From: Simon Davis
Sent: 21 October 2020 11:02
To: simon.robinson [REDACTED]
Subject: BR/244/20/PL Beach Hotel

Just a couple of very early thoughts. We note this is a smaller site area than previously but the remainder of the site is not blue edged. Has the ownership changed? If not, then you need to amend the location plan to blue edge the other owned land.

Document Title:
Existing Elevations

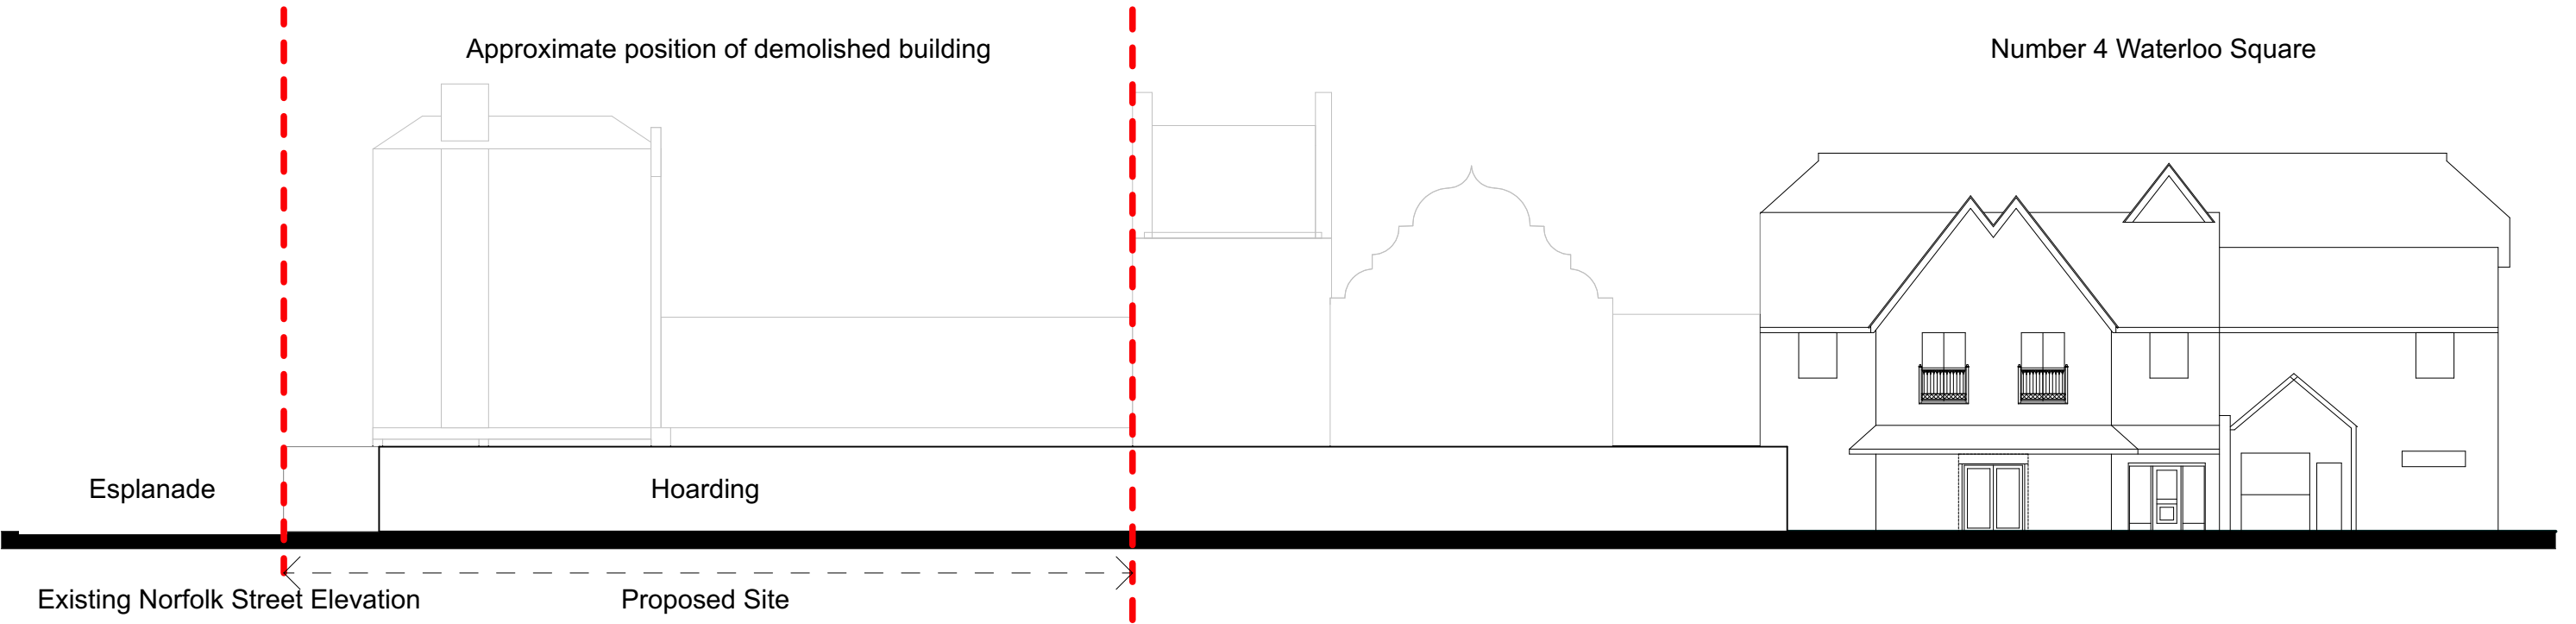
Can you also provide separate plans (elevations) which overlays what was there previously against the proposed.
